Addendum No. 1

RE: Contract # C204057

Johnston County (U-5795)

SR-2302 (Ricks Road) From US-70 To US-301

RICKS ROAD / RAILROAD INTERSECTION DETAIL

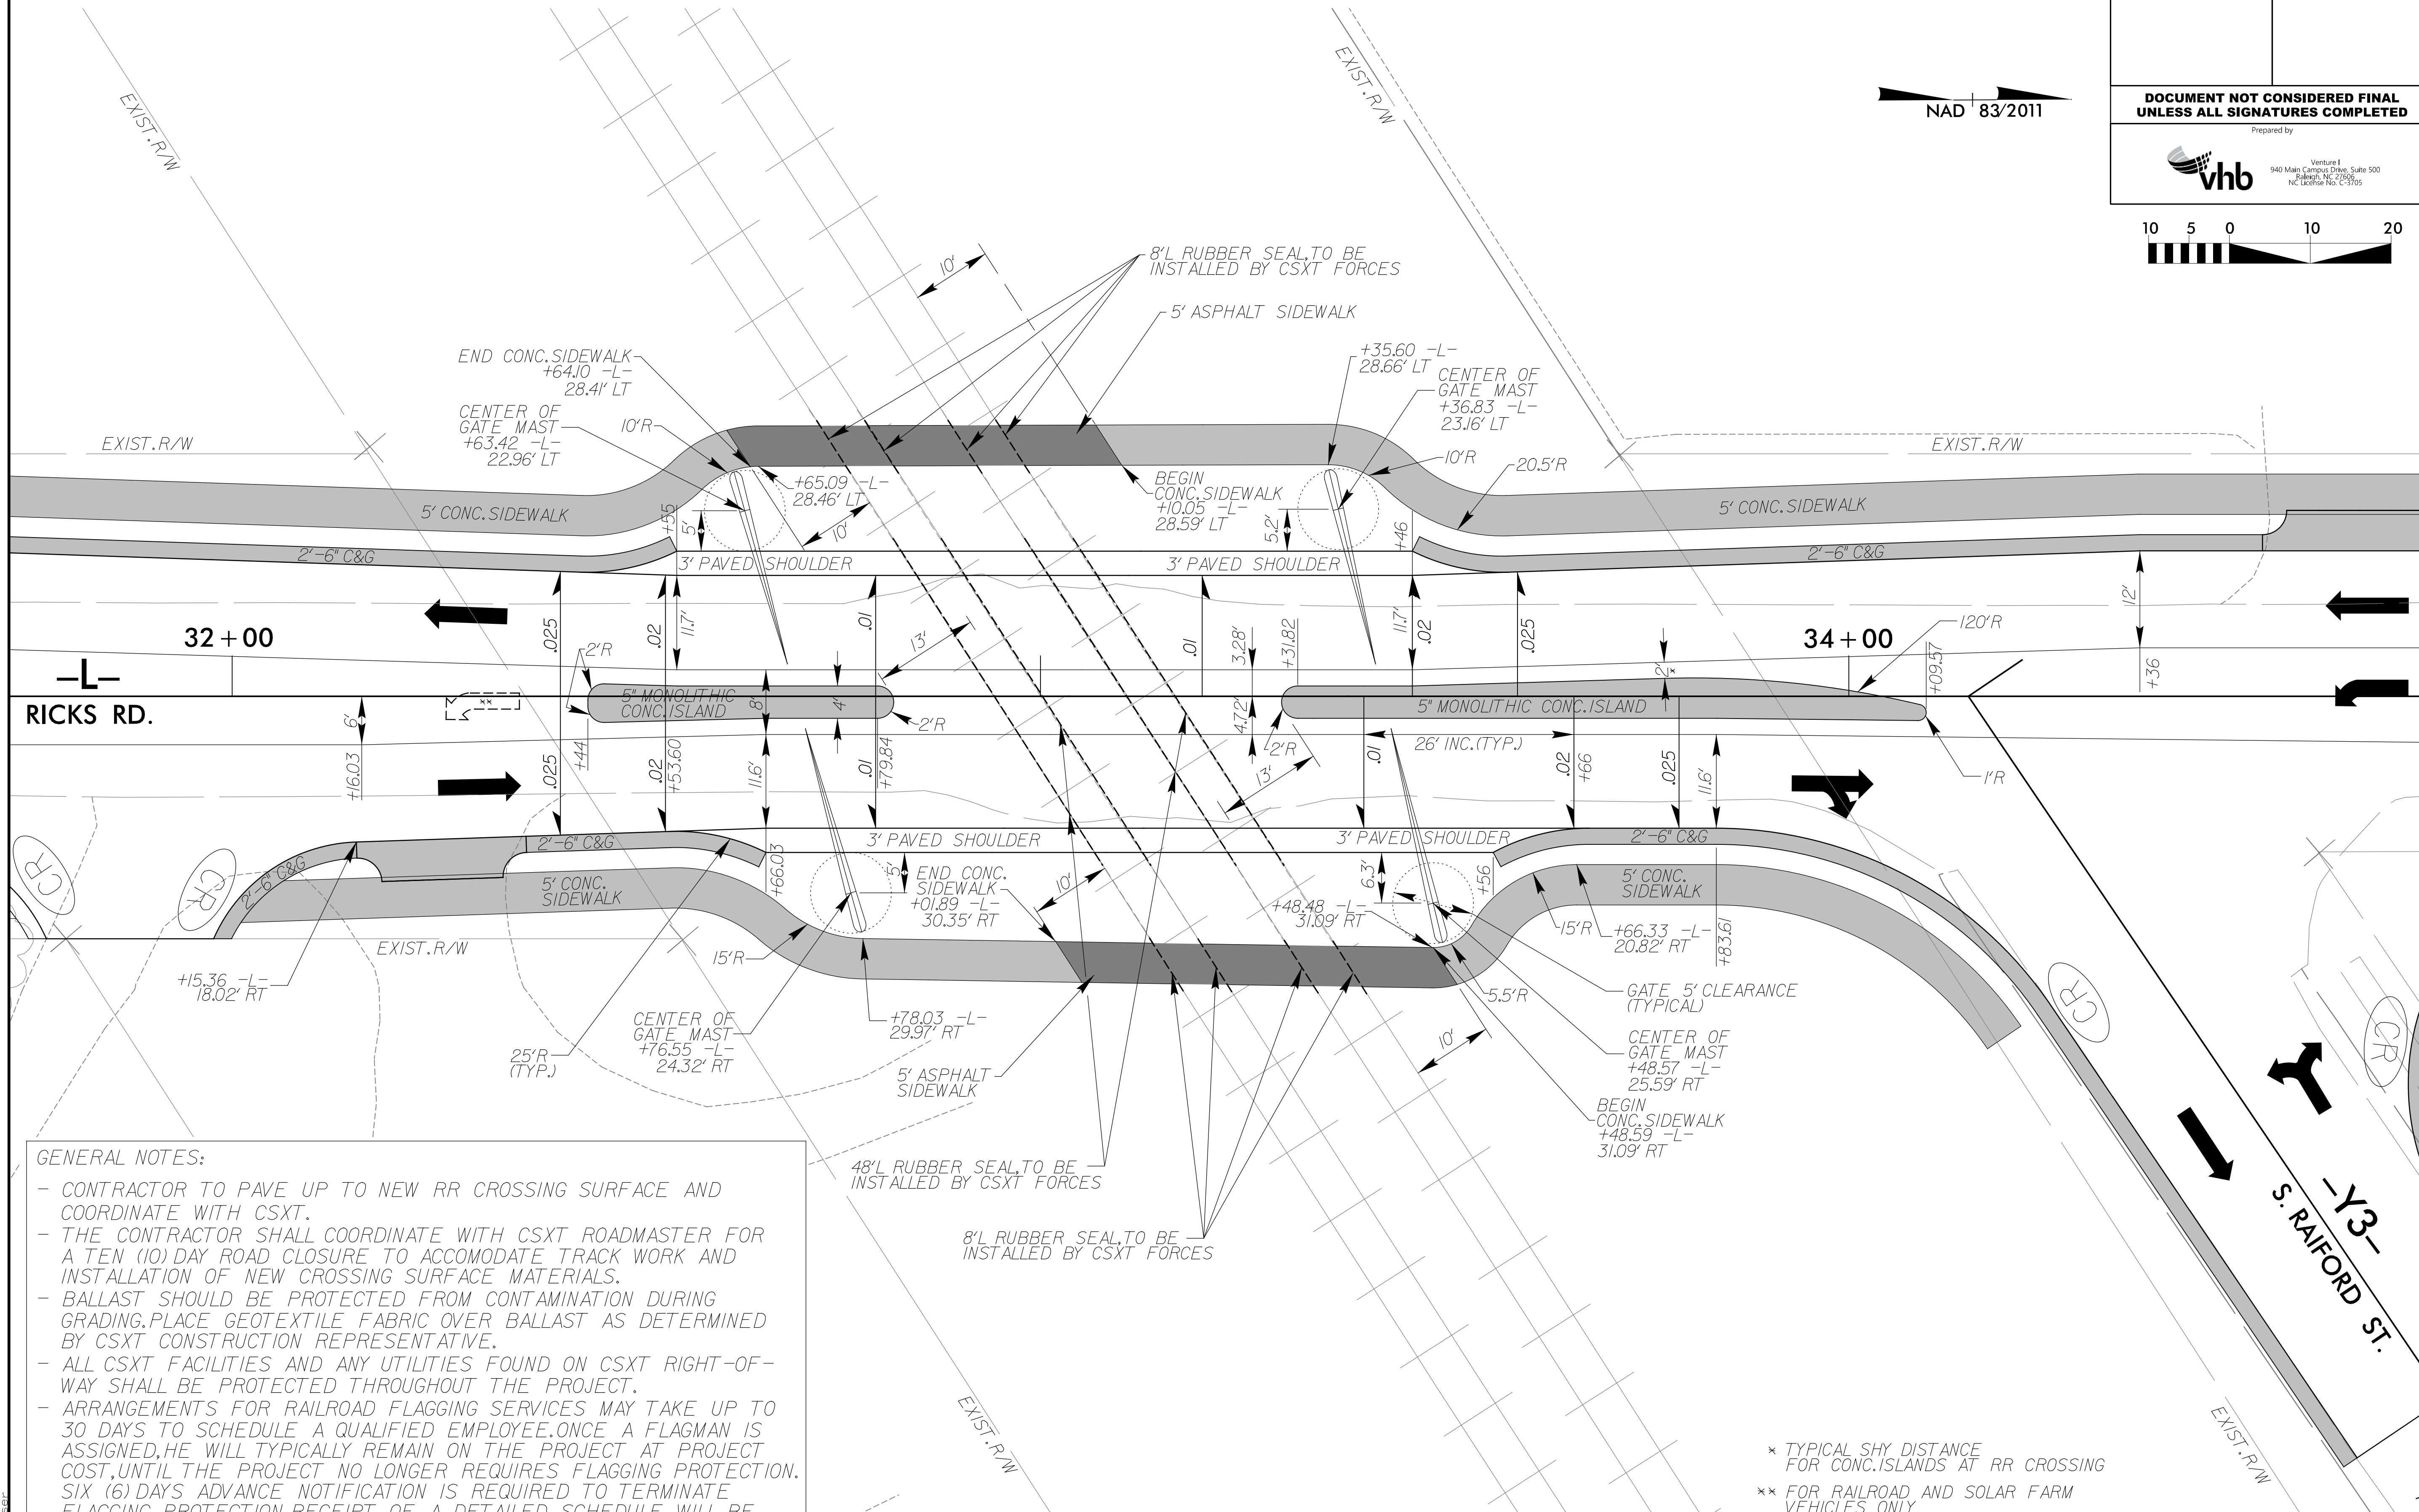
Sheet No.	Revisions
New 2B-1	New sheet to show Railroad intersection details
5	Note added concerning using caution around billboards on Parcel #21 and reference was made to new sheet 2B-1

Please void Sheet No. 5 in your plans and staple the revised sheet thereto. Please staple New Sheet No. 2B-1 after Sheet No. 2A-3 in your plans.
